Response to submission by Newcastle City Council – S96

DOMA Honeysuckle Pty Ltd
'eighteen honeysuckle drive' + 'Edition' Apartments
18 Honeysuckle Drive + 10 Worth Place, Honeysuckle NSW

This report has been prepared in response to a submission made by Newcastle City Council in relation to the proposed modification SSD 6580 MOD 1.

Drawing
PARKING LEVEL 2 PLAN

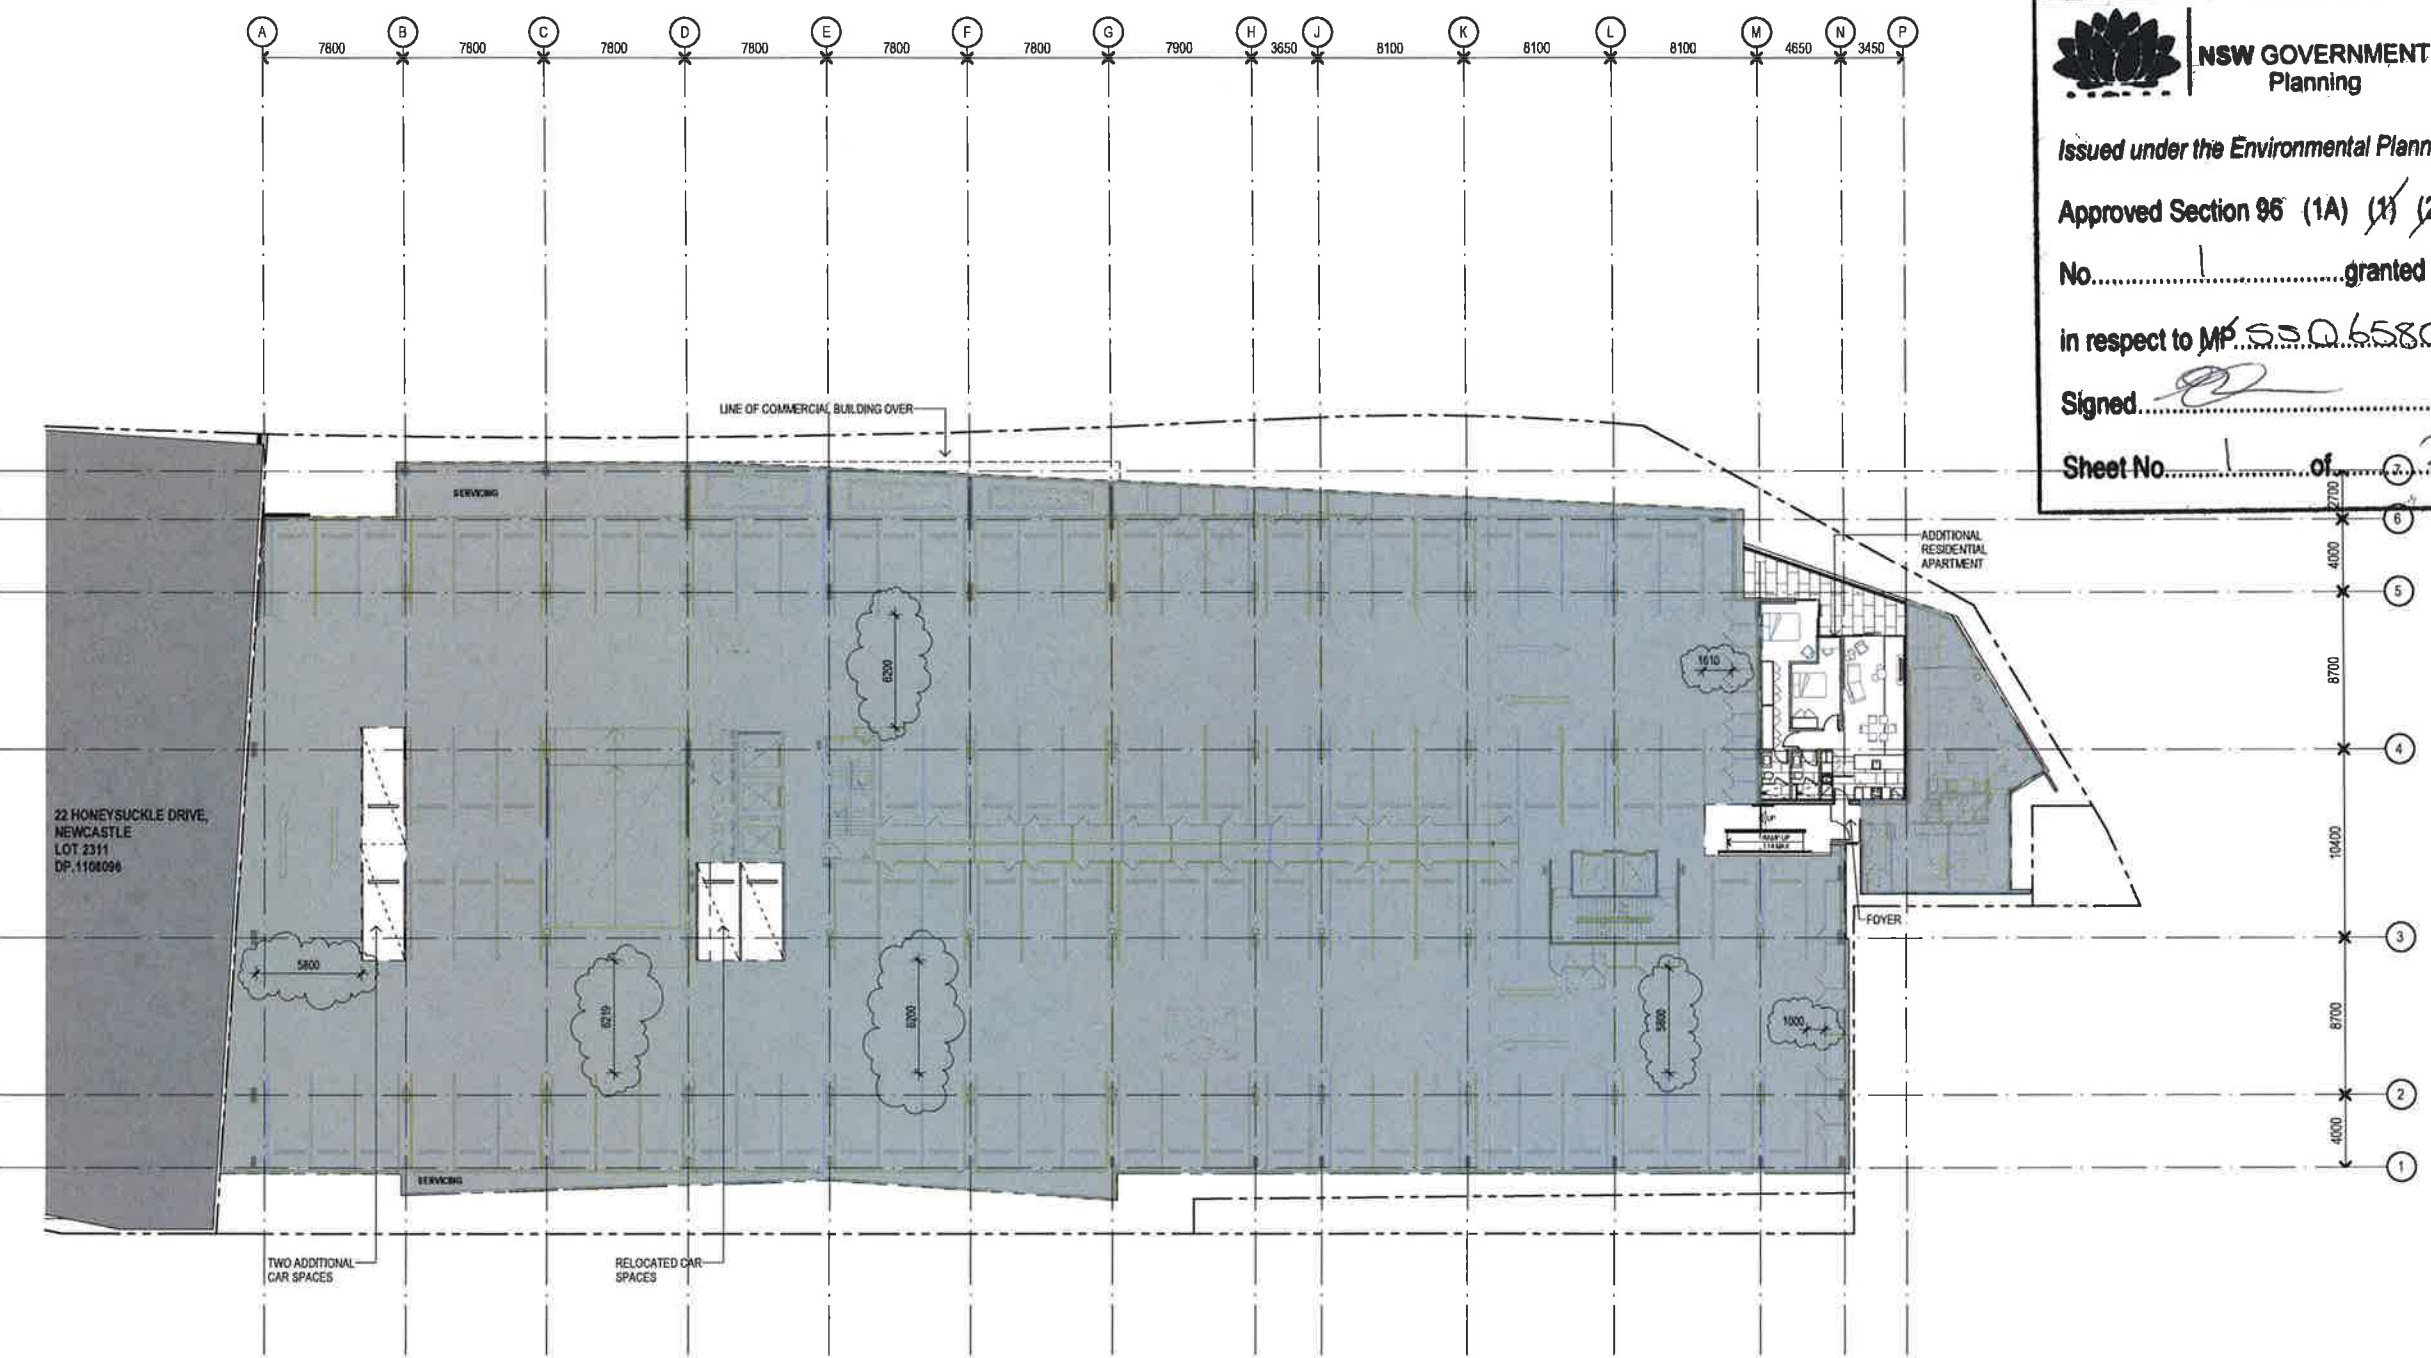
The modified layout of the car park on level 2 of the building has been designed to comply with AS 2890.1 – Parking Facilities. The relevant User Class has been determined as 1A residential, domestic and employee parking in accordance with the standard. The aisle widths are predominantly 6.2m in width, which exceeds the minimum 5.8m acceptable for this class. Individual parking bays are equal to or greater than the 2.4m minimum acceptable dimensions.

Refer revised drawing DA204
